CITY OF ALBUQUERQUE

March 12, 2018

**Re: 9000 Alameda Blvd. Grading & Drainage Plan
Engineer's Stamp Dated Missing
(C20D073)**

ALL INFORMATION SHOWN  
NORTH OF THIS LINE IS EXISTING  
FROM APPROVED GRADING PLAN BY OTHERS  
NO WORK PROPOSED

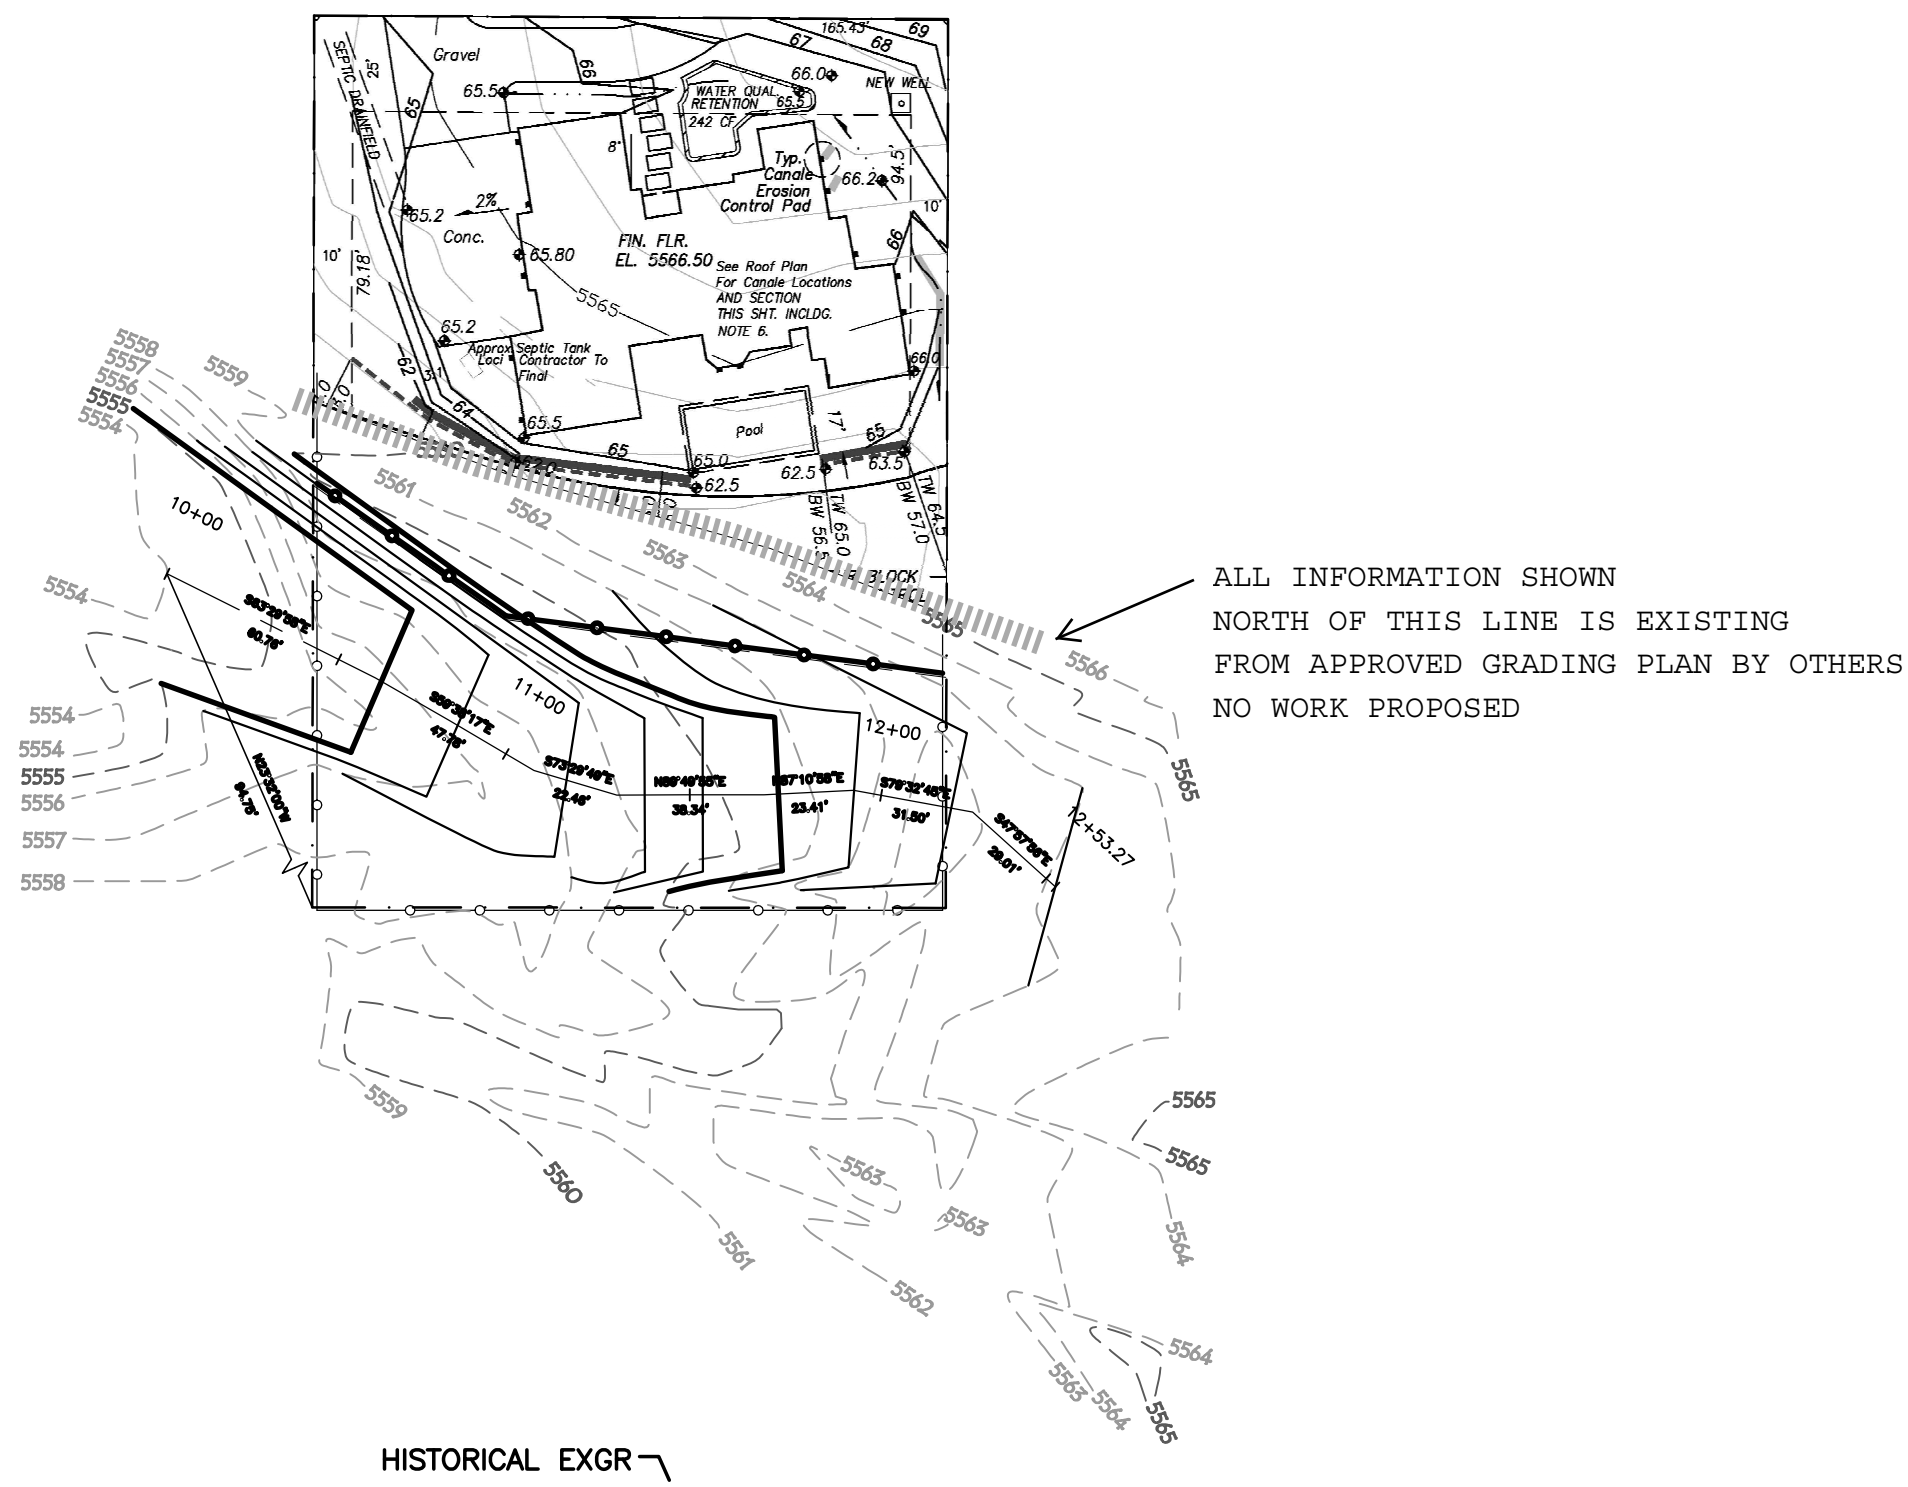
- Add a note prohibiting Construction in the arroyo during the months of July, August, and September.
- Show the proposed grades necessary to restore the floodplain drainage capacity with proposed contours and spot elevations. Verify that the proposed trapezoidal section will restore the original cross sectional area by plotting the finished grade on the sections.

- Include a profile of the arroyo showing existing and proposed grades. Add a typical section, about 30' flat bottom trapezoidal channel.
- Extend the grading upstream of the property about 20' as necessary to restore the original grade there.

- Provide sufficient horizontal and vertical control for construction staking and as-builts.
- Show a Public Drainage Easement 55' wide at the east PL, 105' wide at the west PL, and 70' wide at a point 50 east of the west PL. Provide the signed and notarized original easement to Madeline Caruthers along with a check for 25\$ payable to Bernalillo County.
- Show the relocated fence outside of the Public Drainage Easement, and identify the existing fence to be removed from within the public drainage easement.
- An ESC plan must be submitted to Stormwater Quality Control. After the ESC plan is approved an ESC Permit must be obtained prior to beginning construction.
